**Planning consultation: Application by One Earth Solar Farm Limited for One Earth Solar Farm. The Examining Authority's request for information and follow up to Examiner's Question 3.**

**Location: One Earth Solar Farm**

## Annex A: Natural England's Response to the Examining Authority's Third Written Questions

# Annex B: Natural England's Updated Comments on Cumulative Assessment of Soils from D4

Drawn Date:
2025-01-27

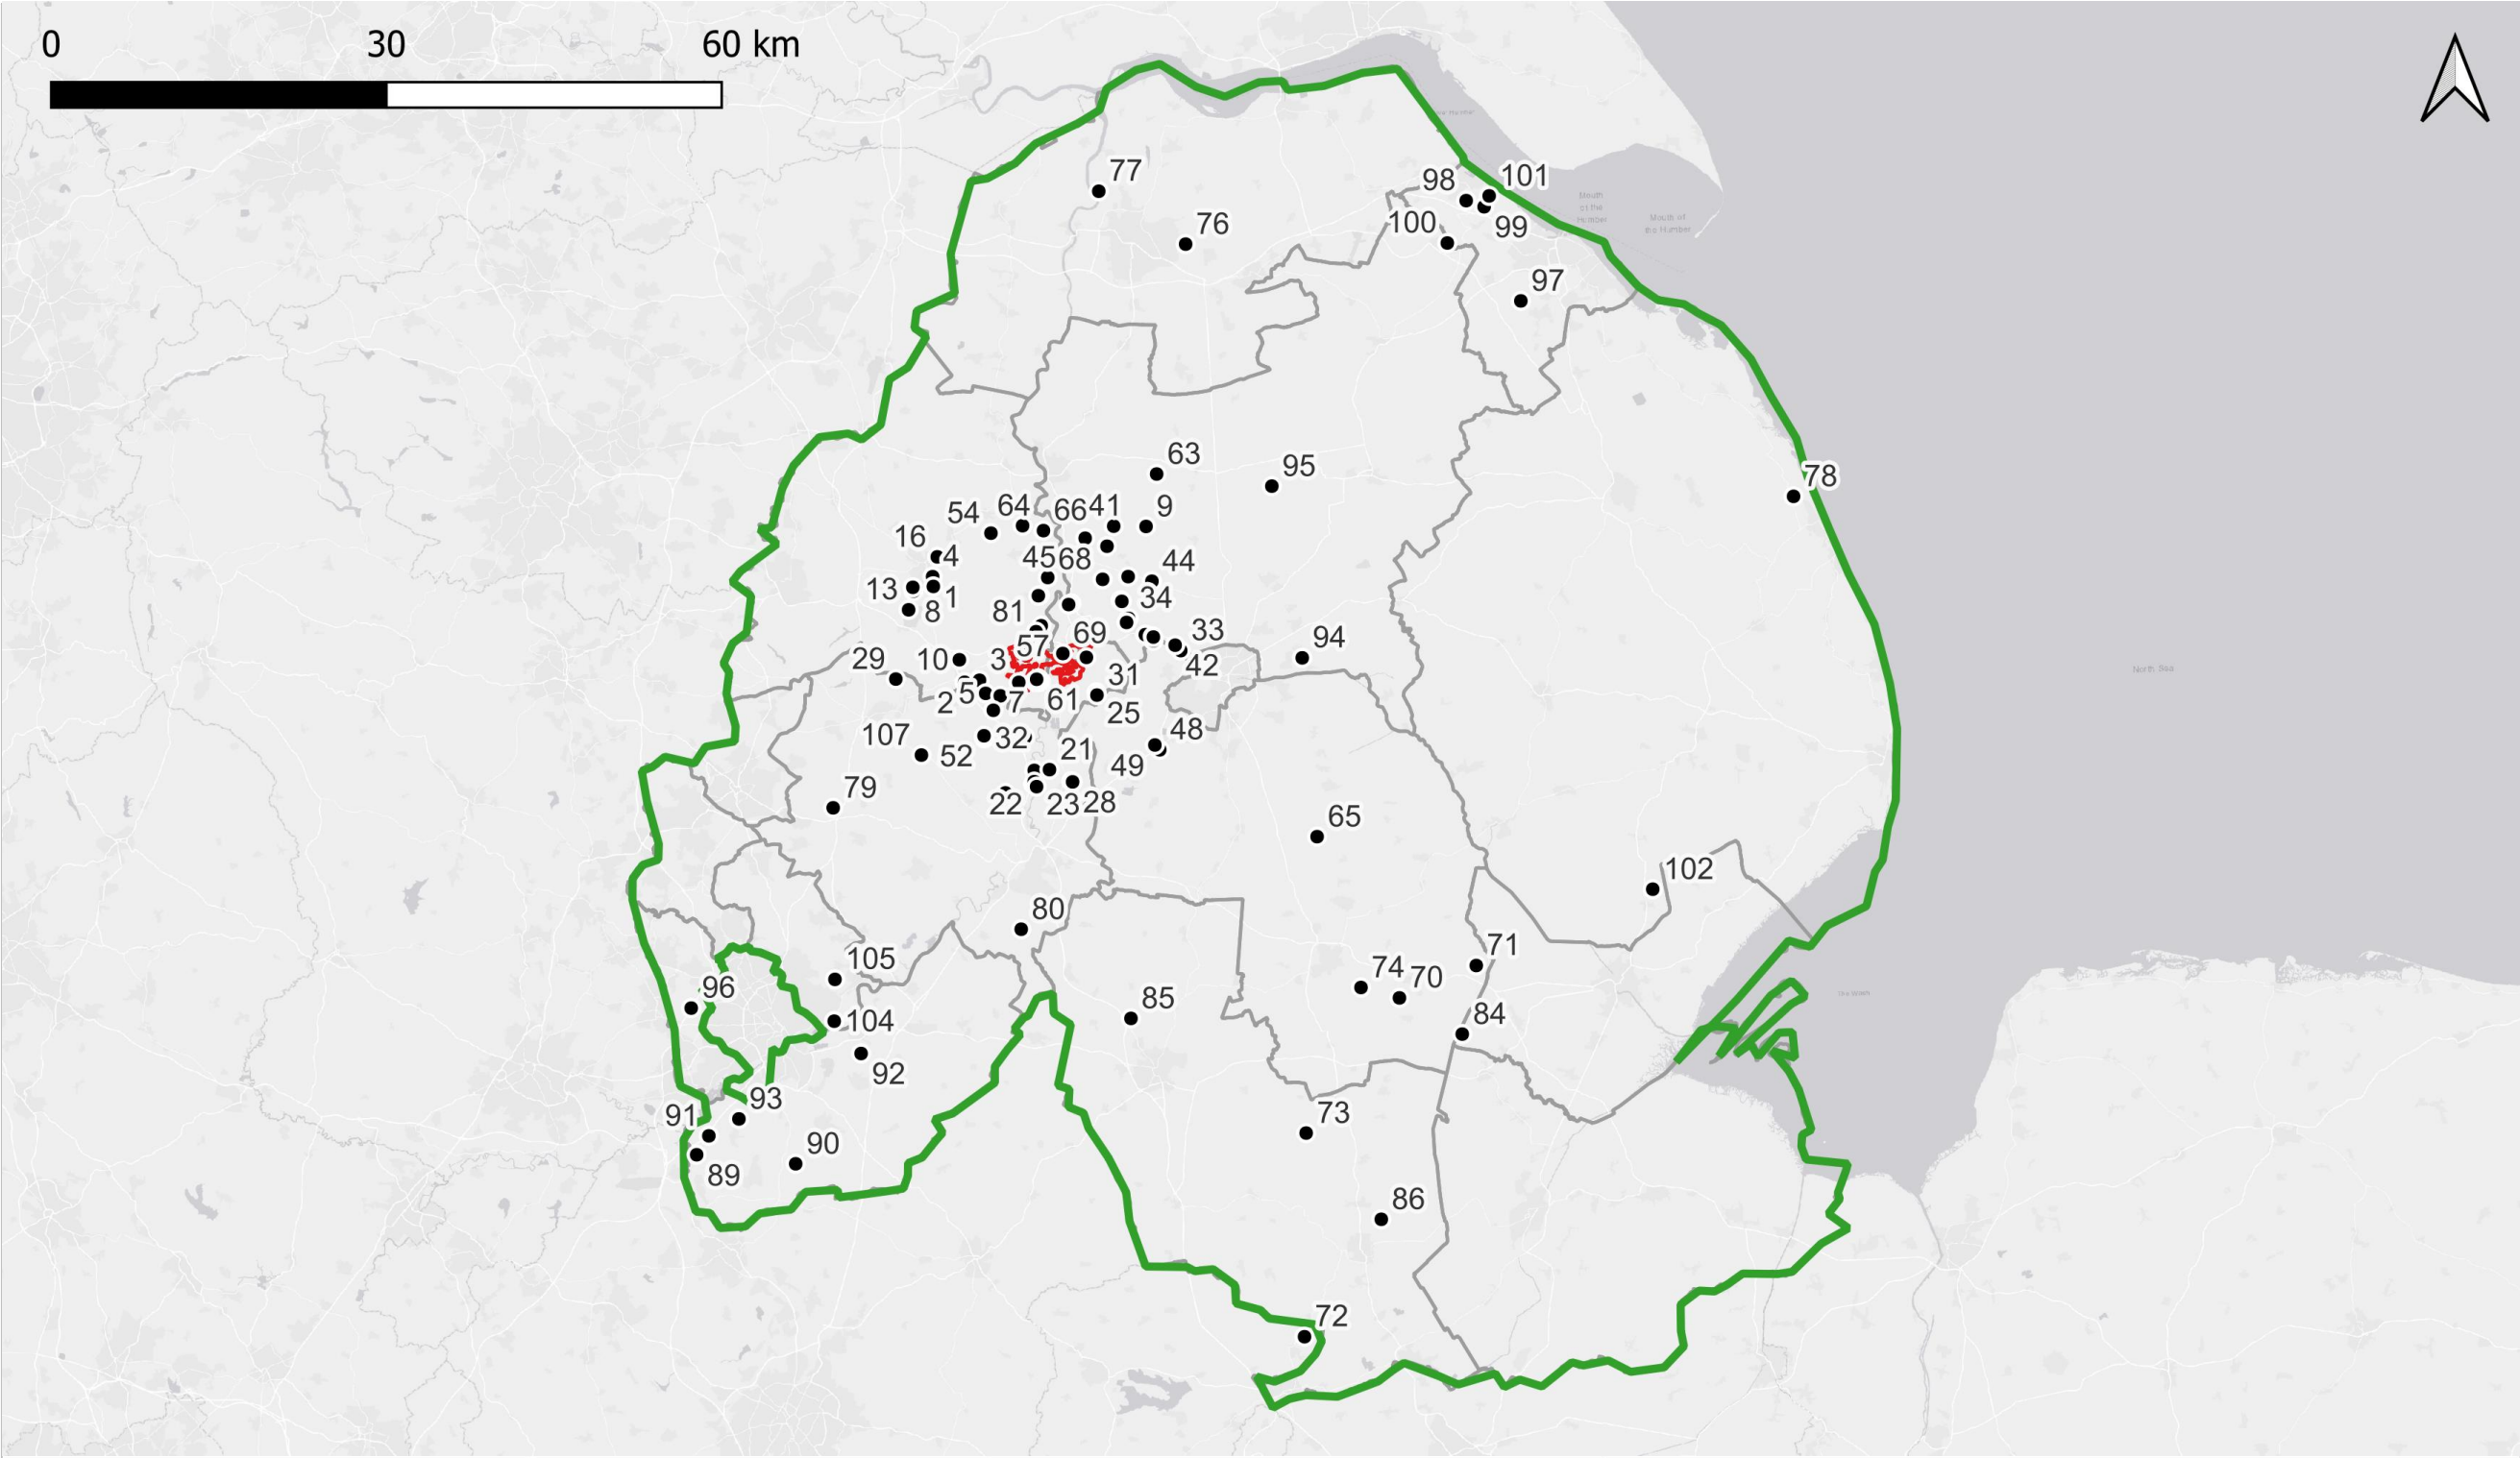
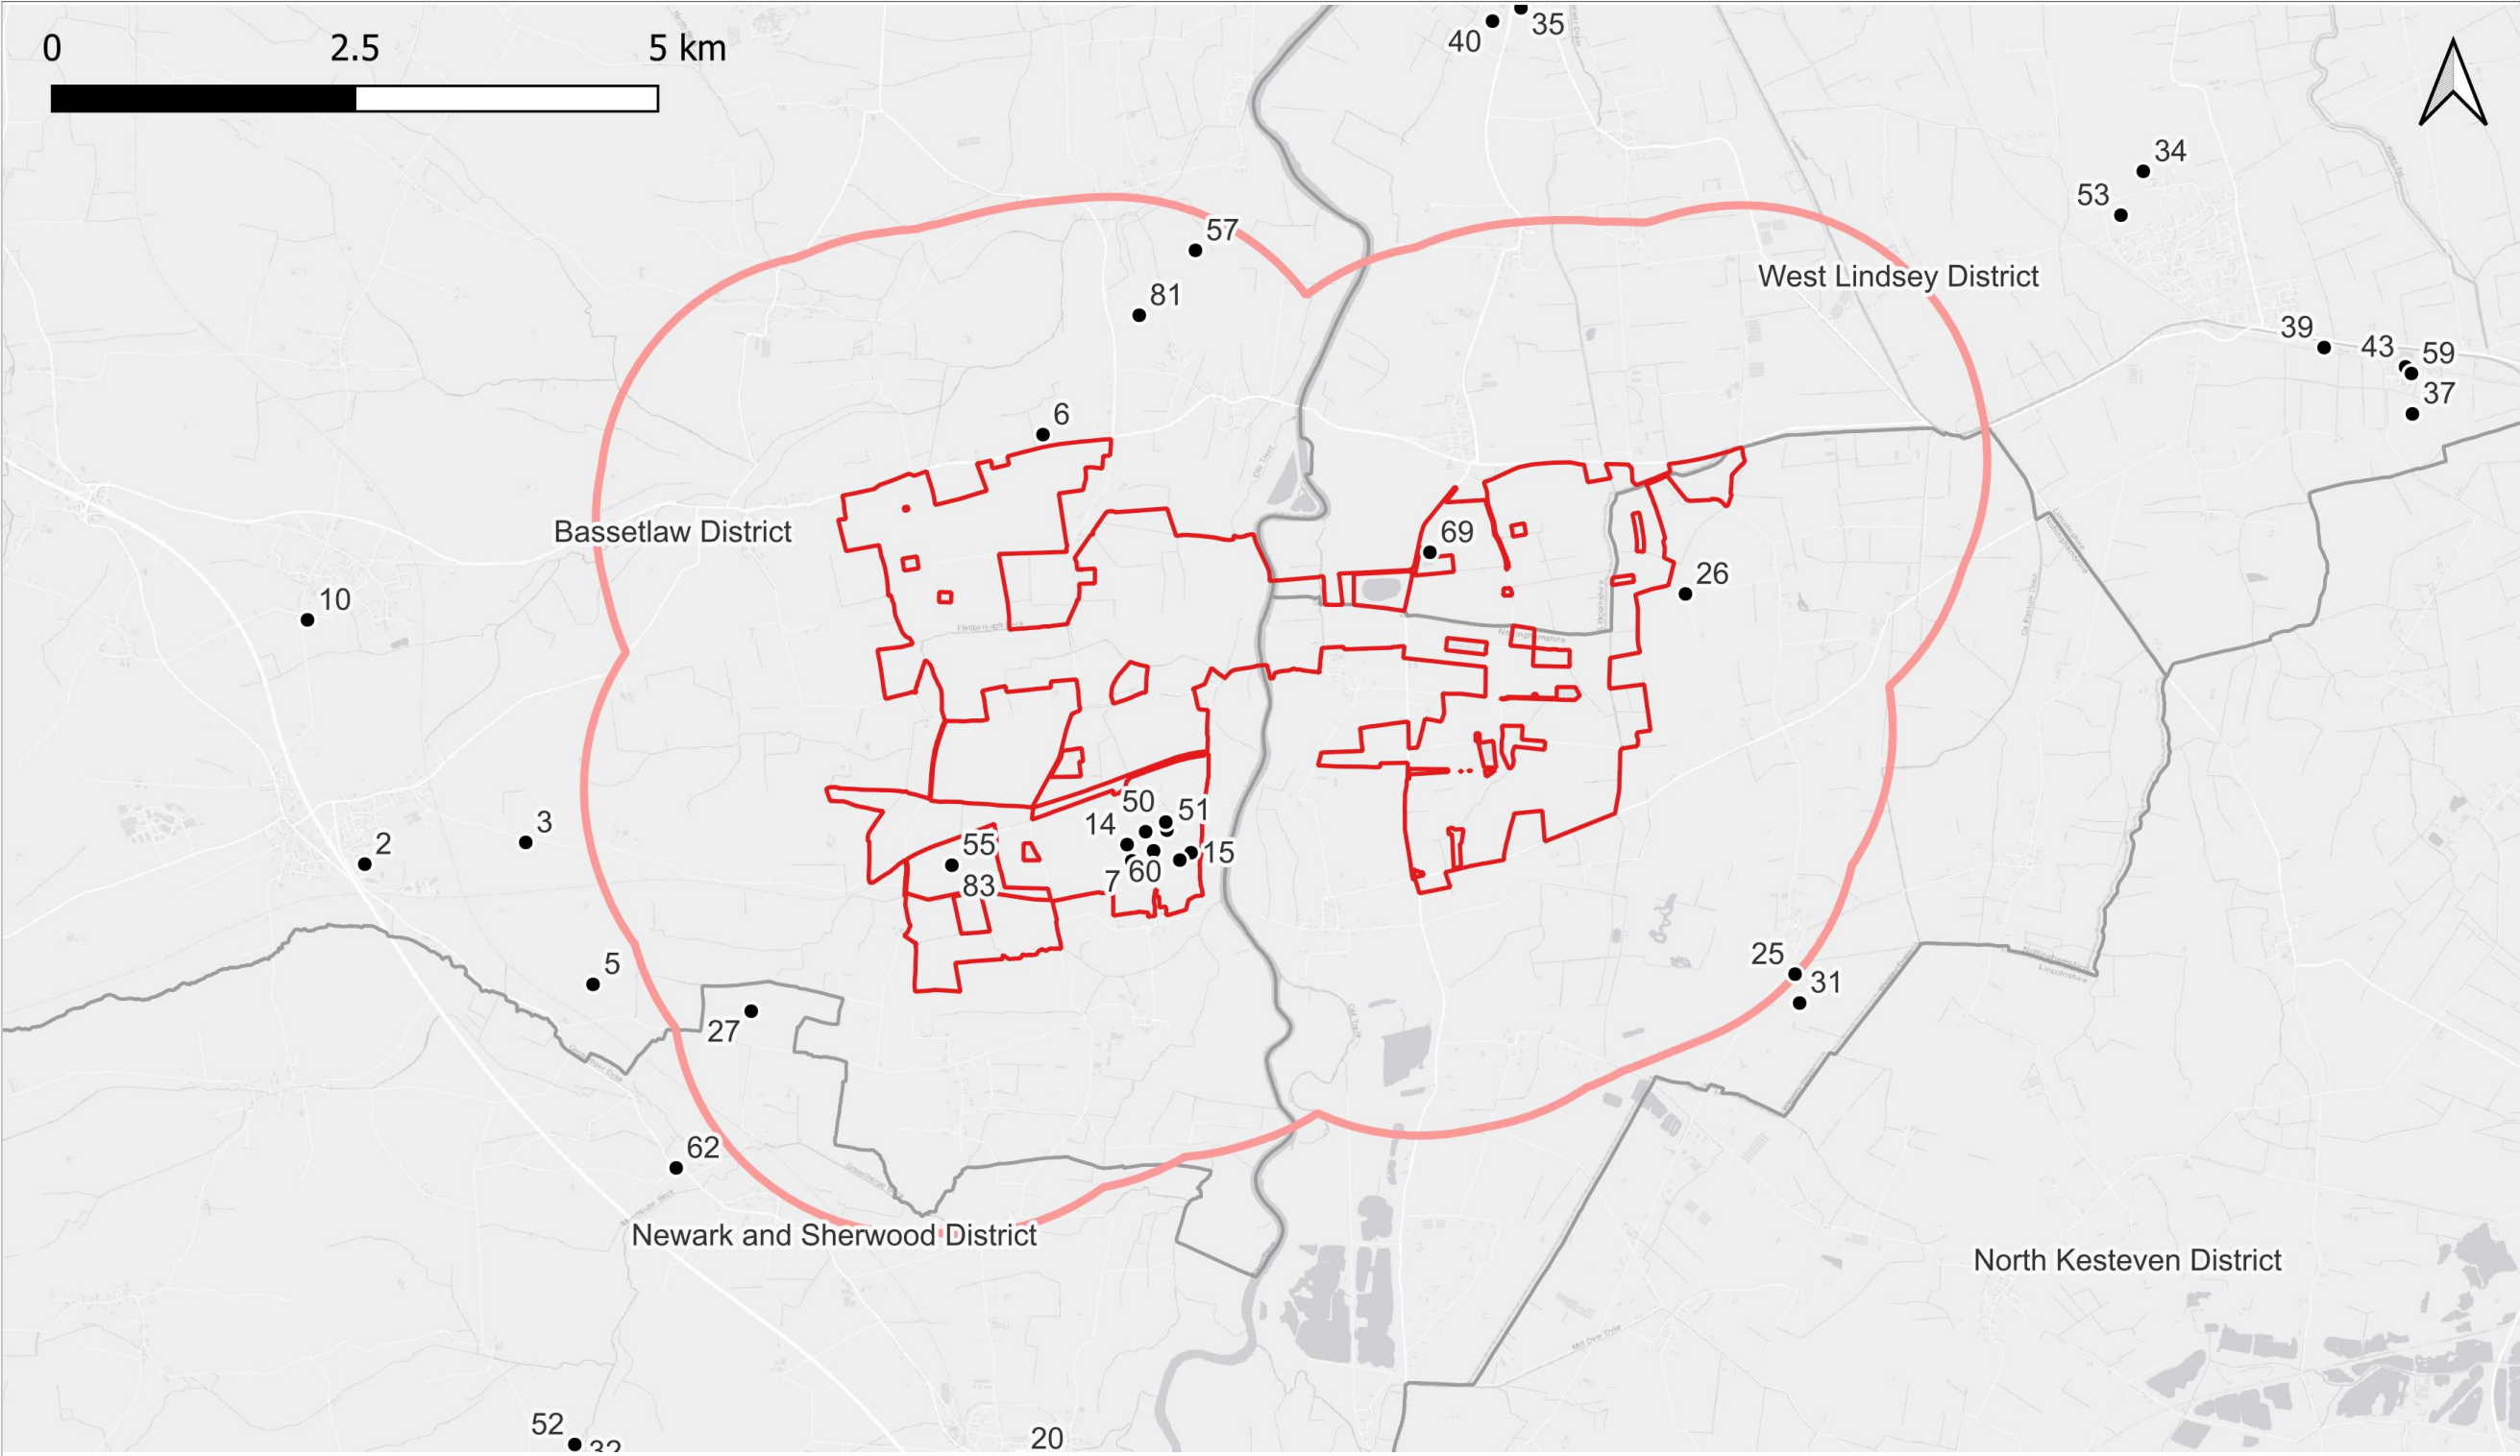
**18.3.19** Natural England are broadly satisfied with the regional Zol and the information provided within ES Volume 3, Figures 18.1 to 18.8 [EN010159/APP/6.20] for a regional cumulative assessment, however we refer the applicant back to the comment above (table 18.2)

D6 Update: No further comment.  
D7 Update: No further comment.
